Temperature Controlled Warehouse Facility (SSD-8586218)
Response to Submissions

Attachment A: Request for further information

TITLE			
SITE PLAN			
DATE	SCALE	PROJECT NO.	DWG NO.
26/08/2020	1 : 500 @ A1	20150	DA101
			REVISION
			B

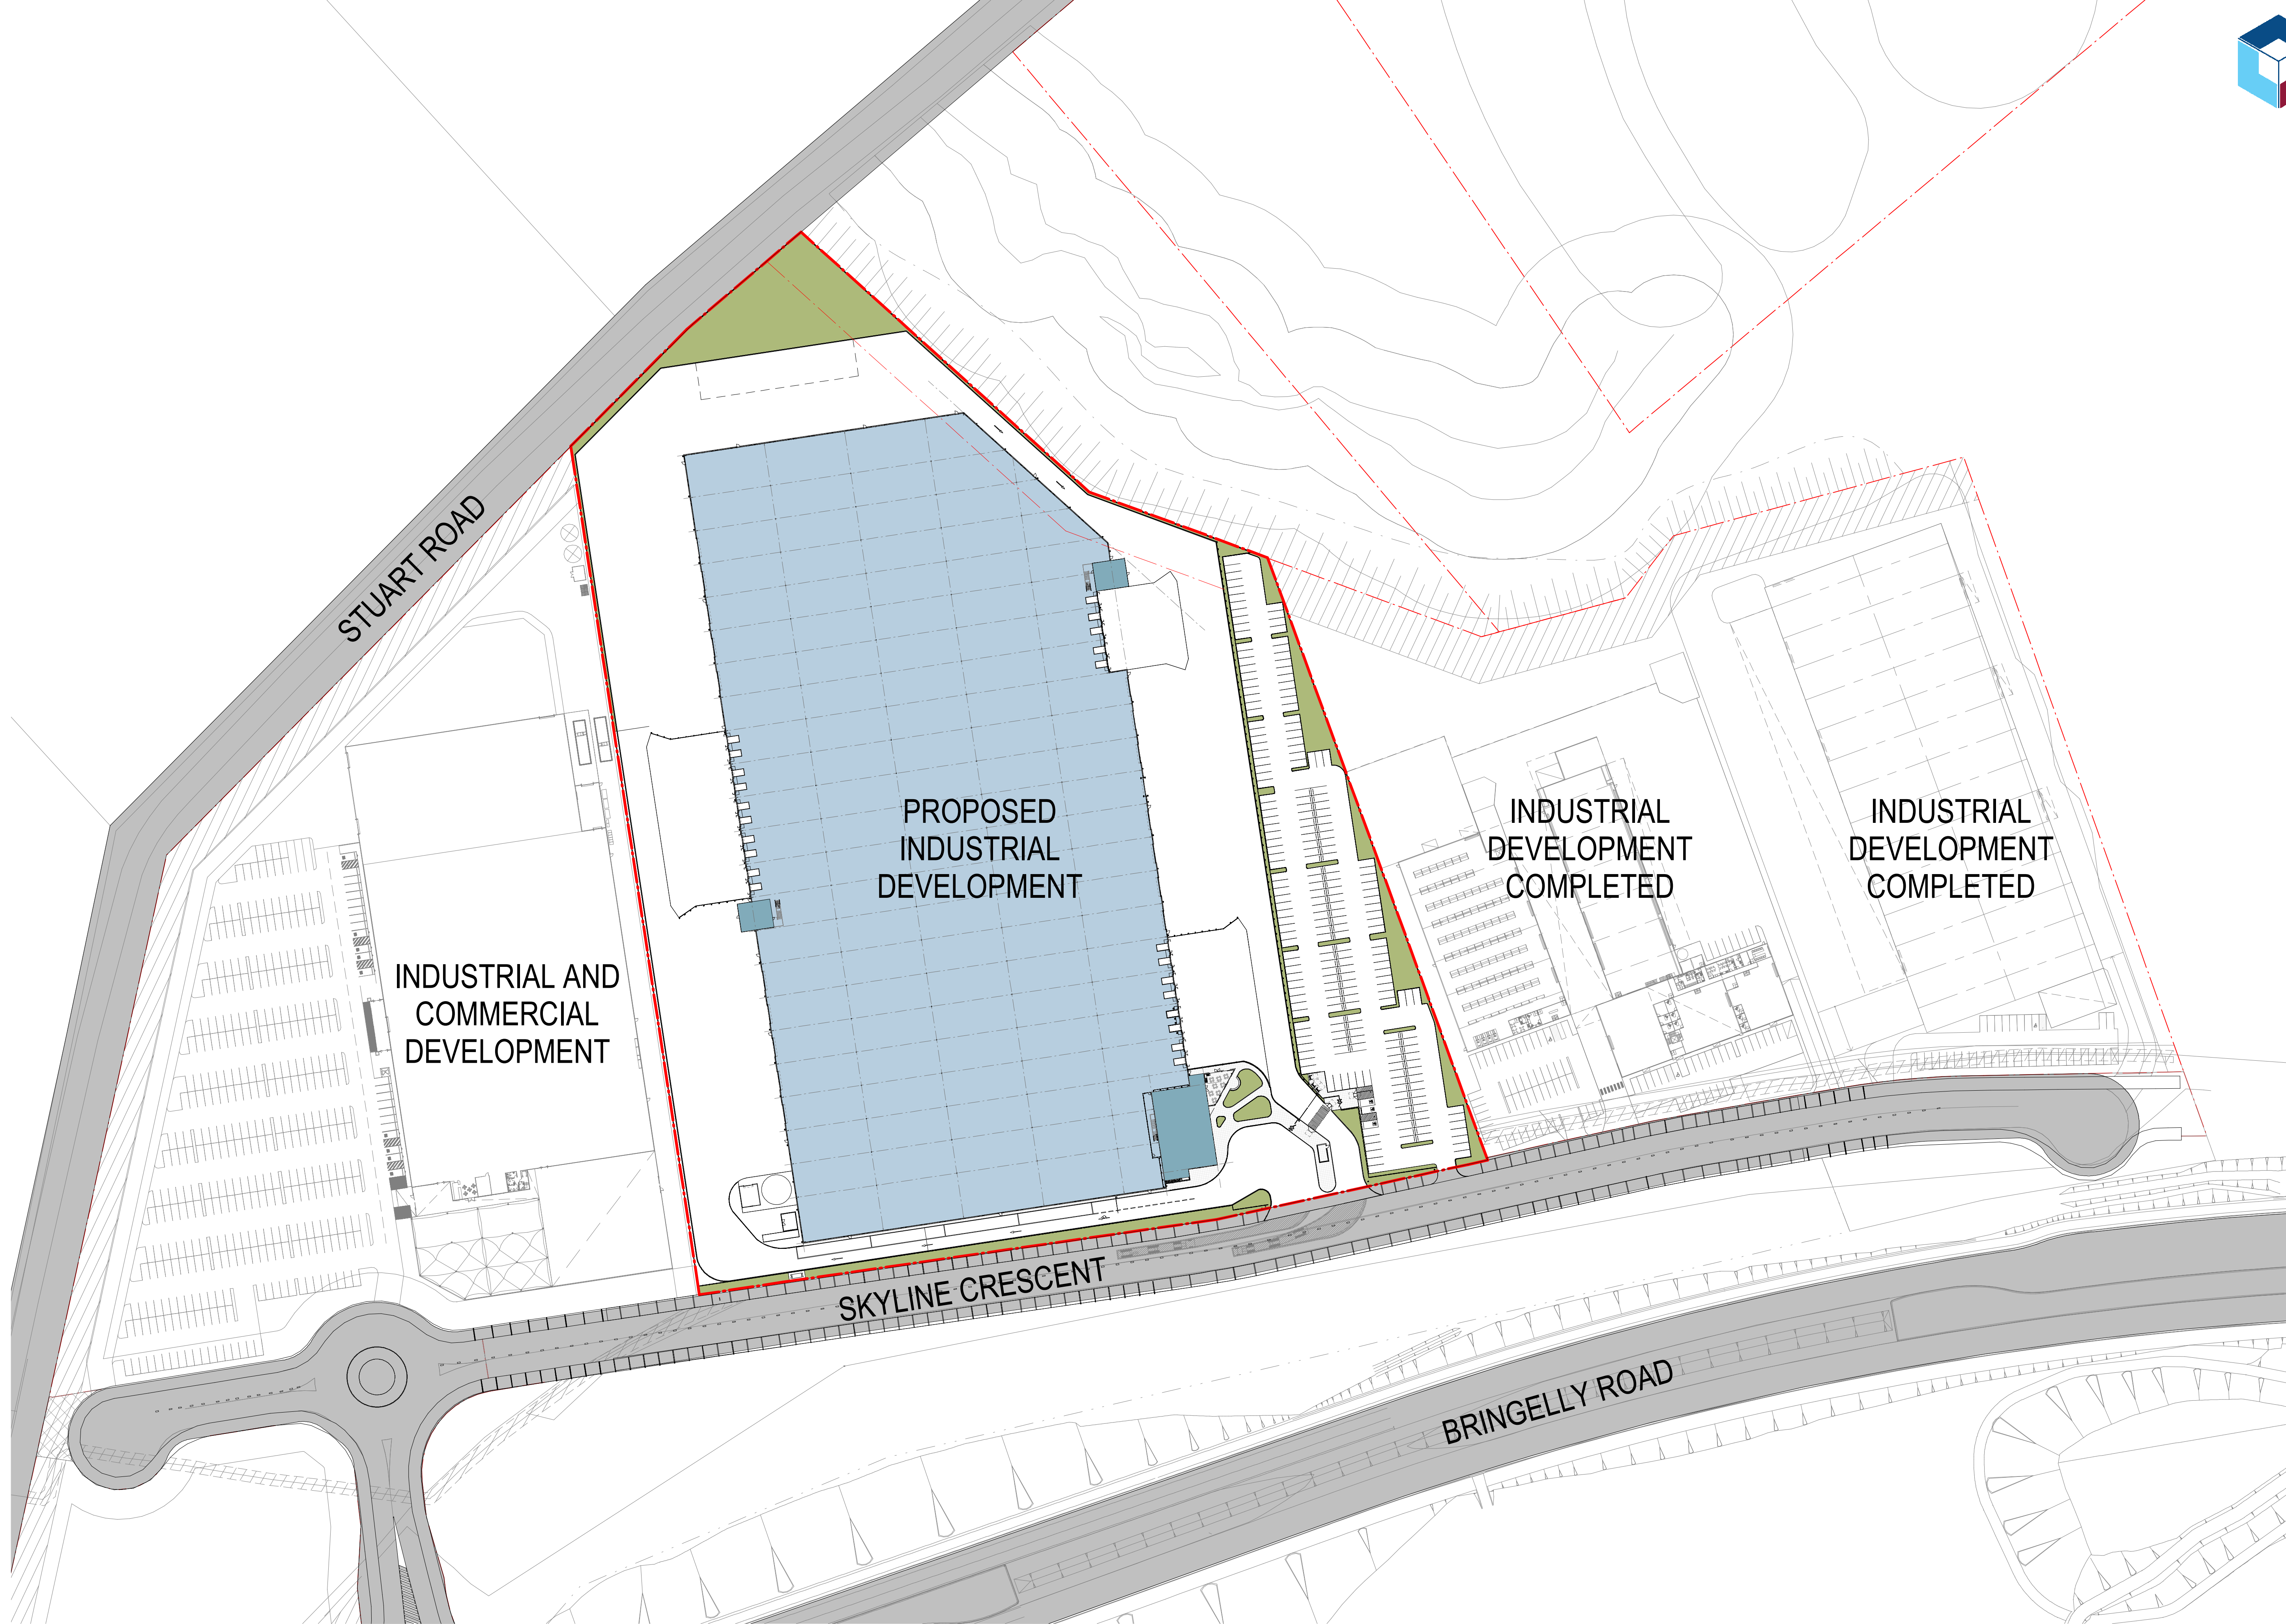
It is acknowledged the proposal meets the Site Design Guideline's setback requirements in relation to the Stuart Road boundary, however, part 2.1(1)(b) requires a 5 metre (m) wide vegetation buffer to this boundary, the development proposes 3 m.

In addition, 2.5(5) also requires a 15m setback from the boundary to the riparian zone, however, the development proposes approximately 8.4m.

4 WEST ELEVATION 1 : 400

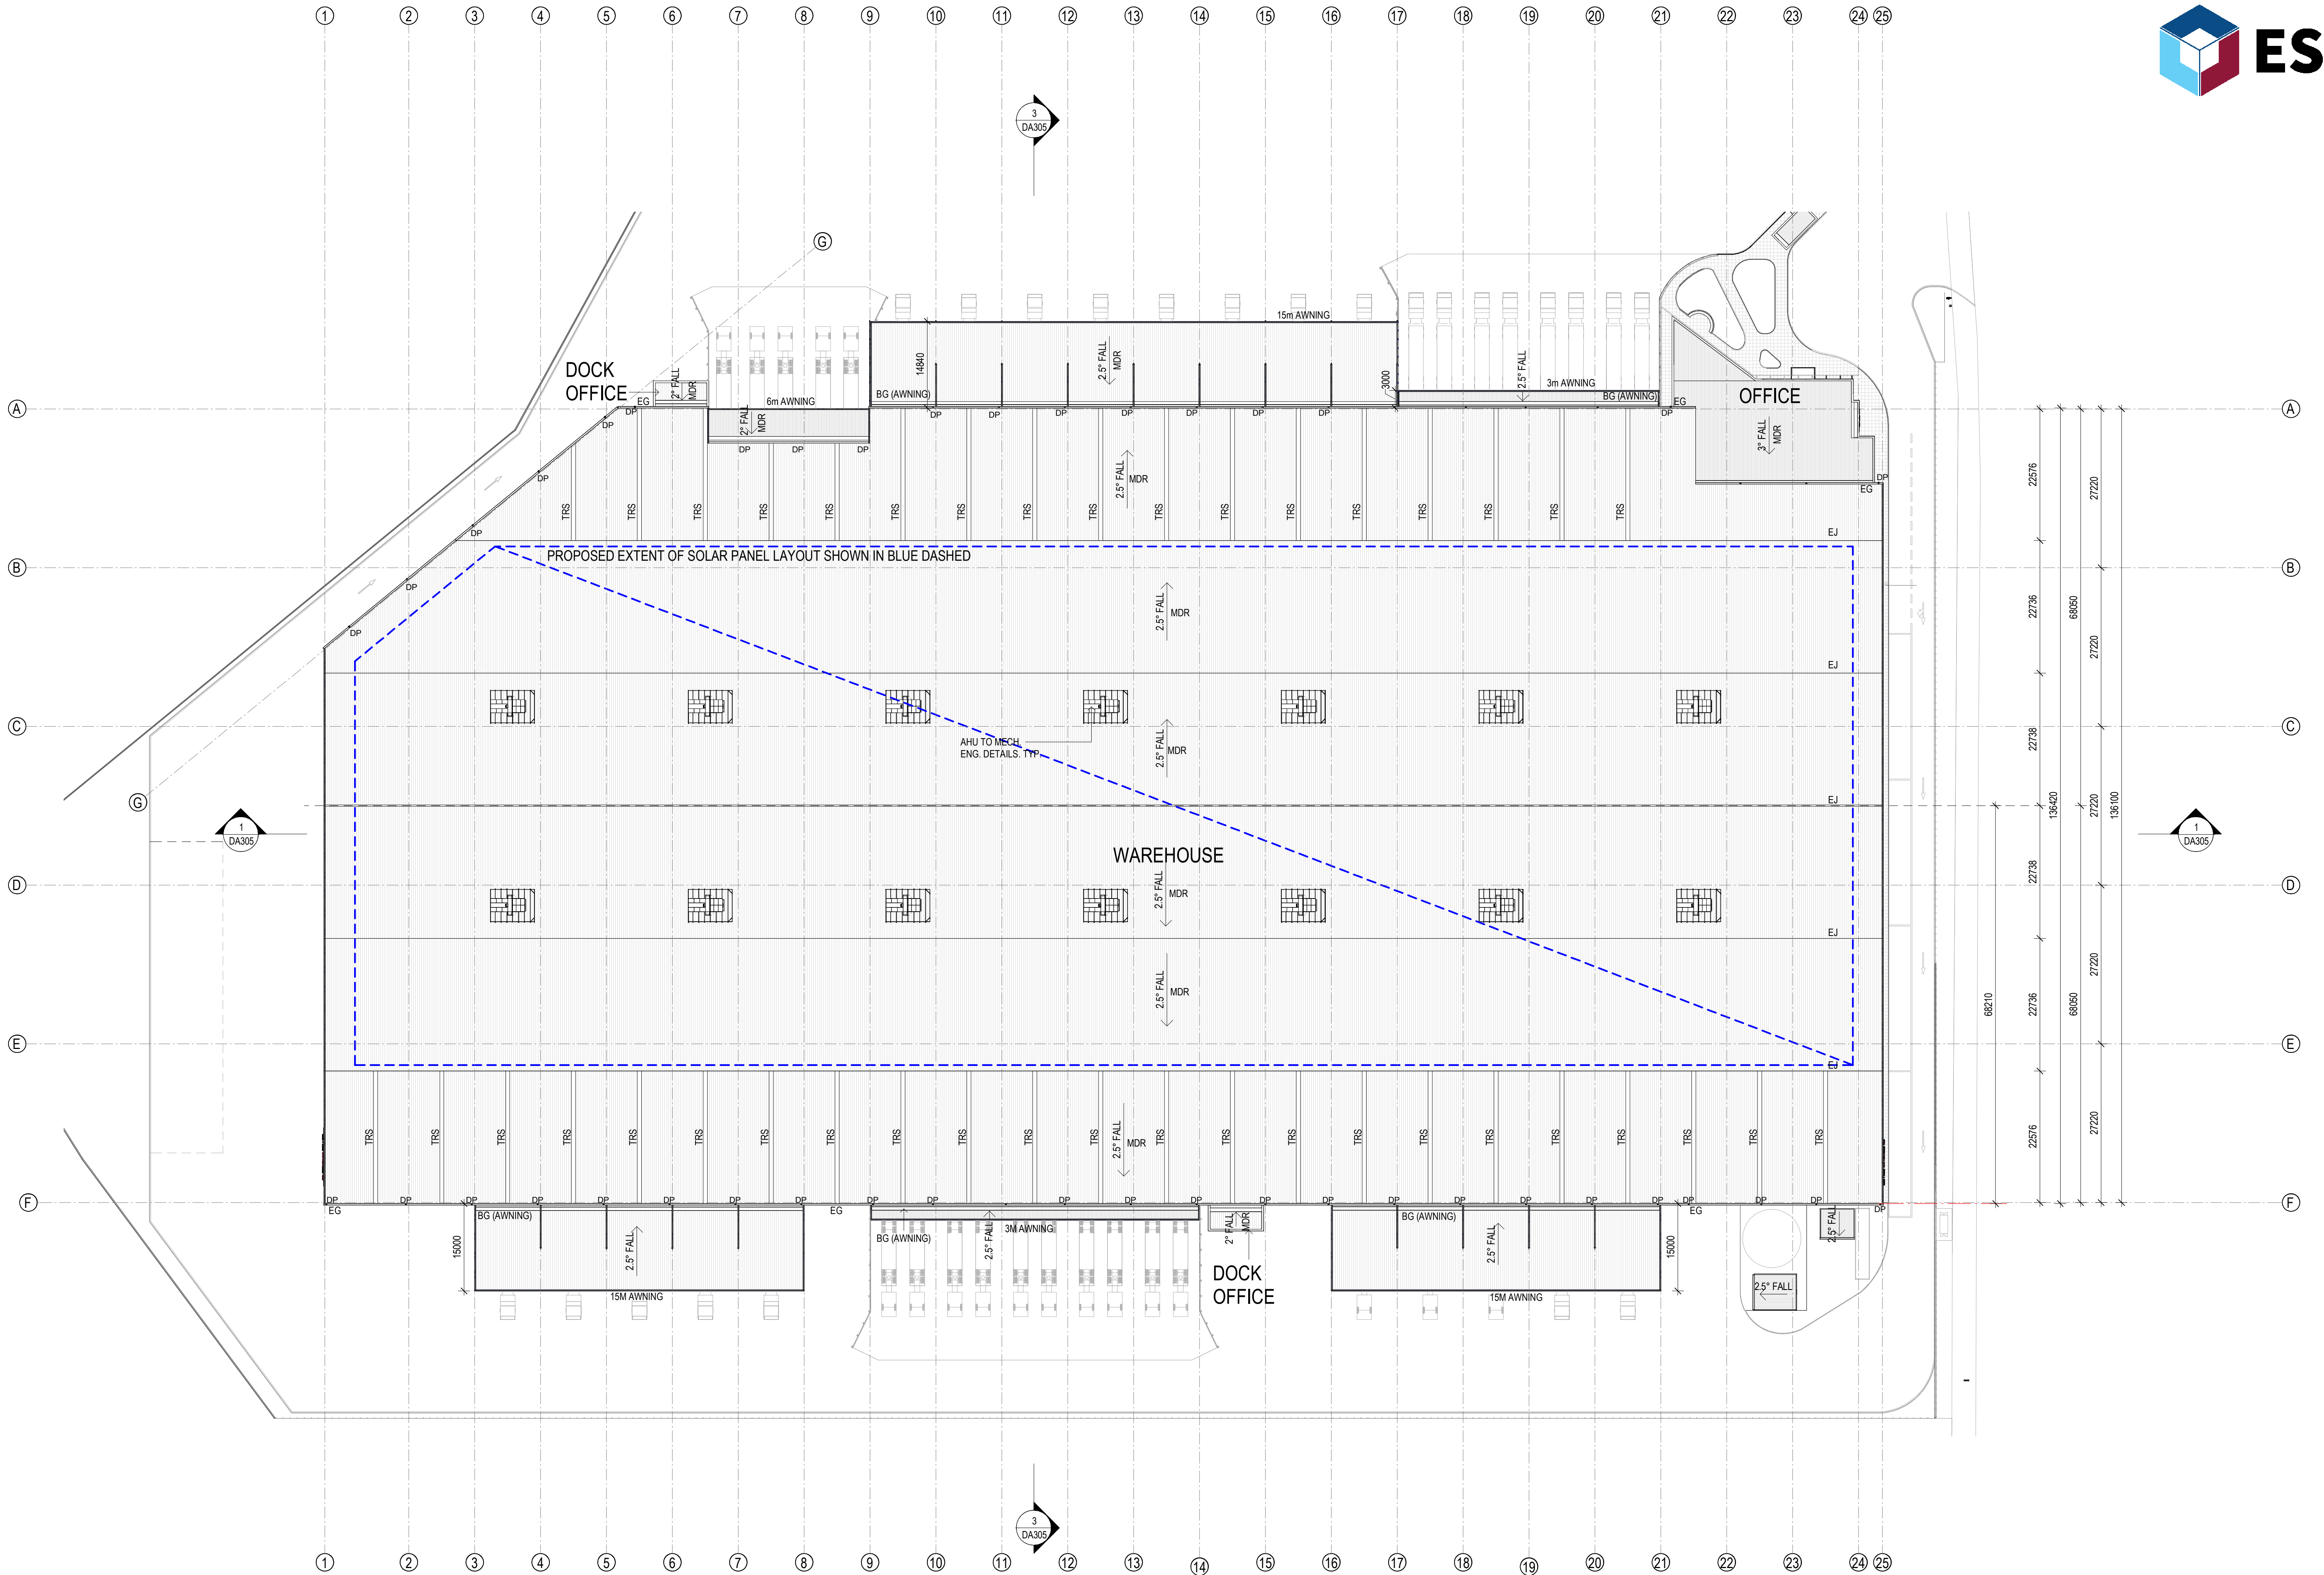
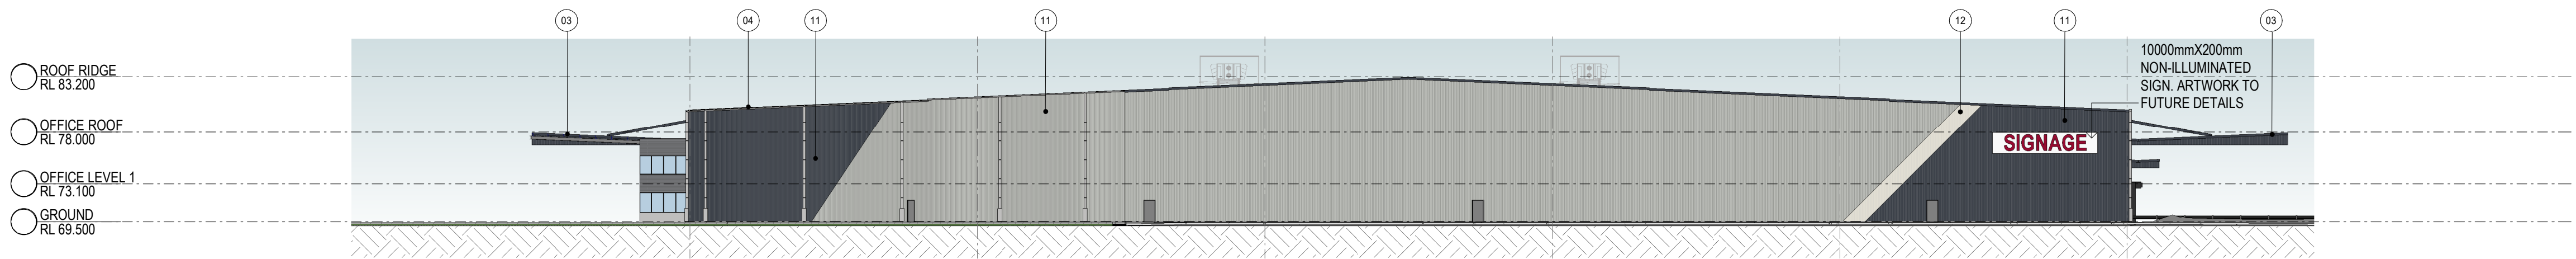
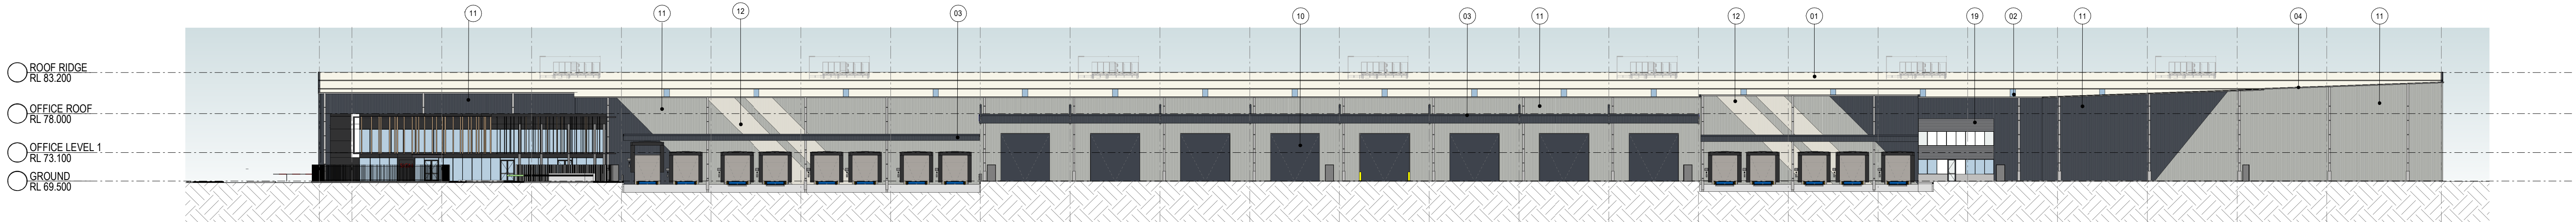
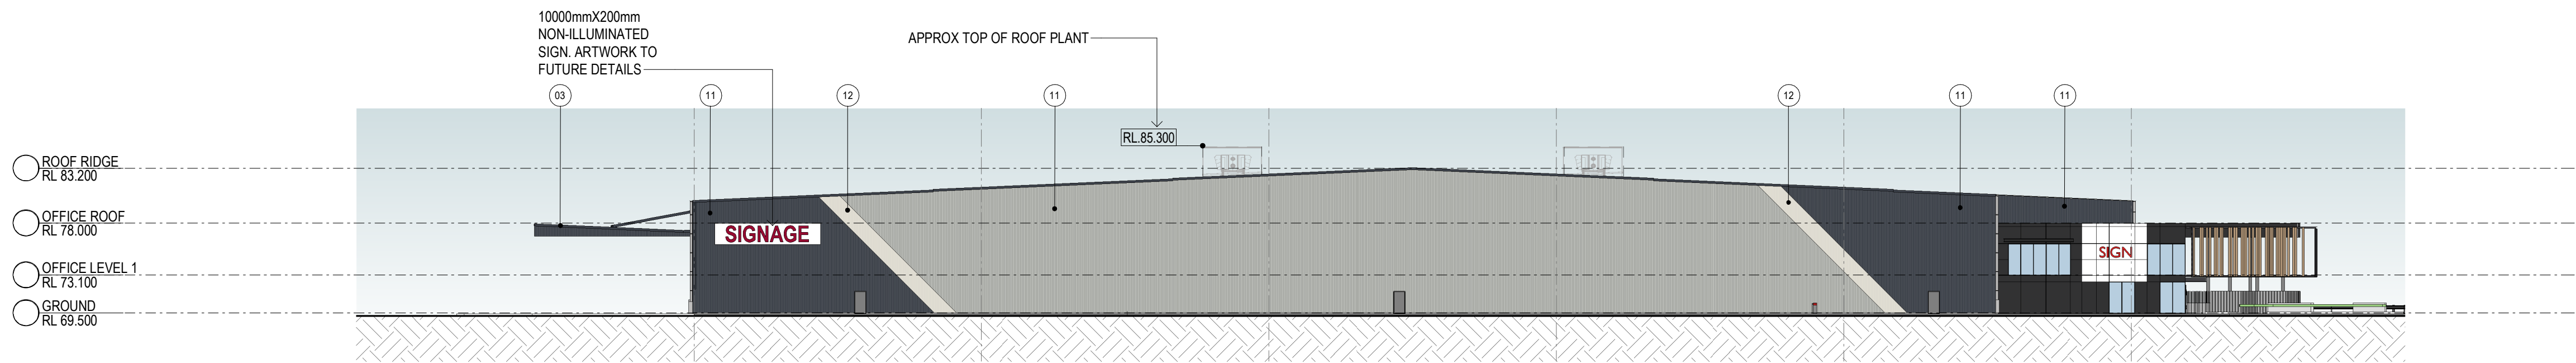
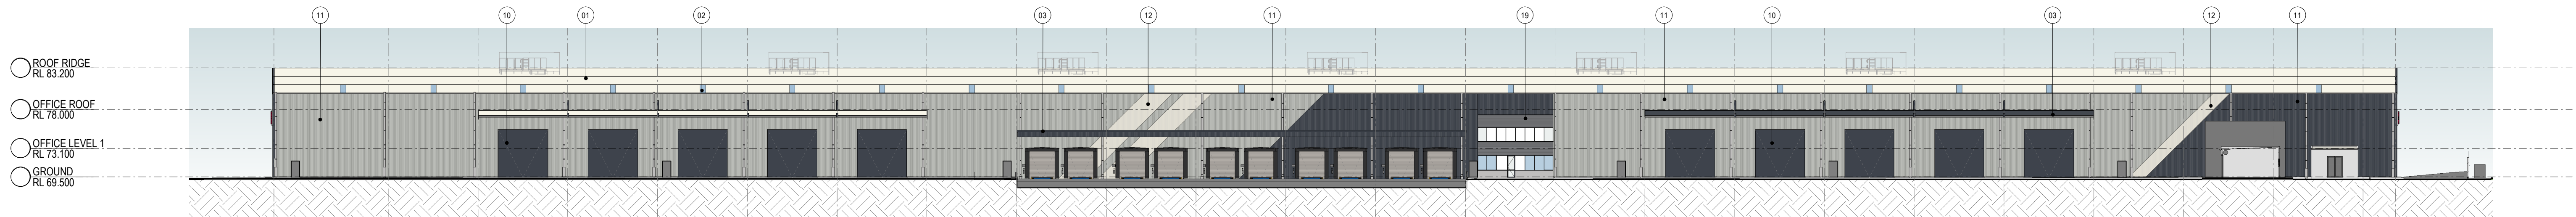
It is noted the architectural drawings show roof plants with approximate heights only, resulting in a building height of 15.7m. Part 2.3(4) of Site Design Guidelines notes maximum height is 14m, with taller buildings permitted where it can be demonstrated certain criterion can be met. A review of the EIS does not appear to address the height inconsistency with the concept approval. As such, please provide clarification on the building height, a full assessment against the guidelines and if required, make changes to the architectural plans.
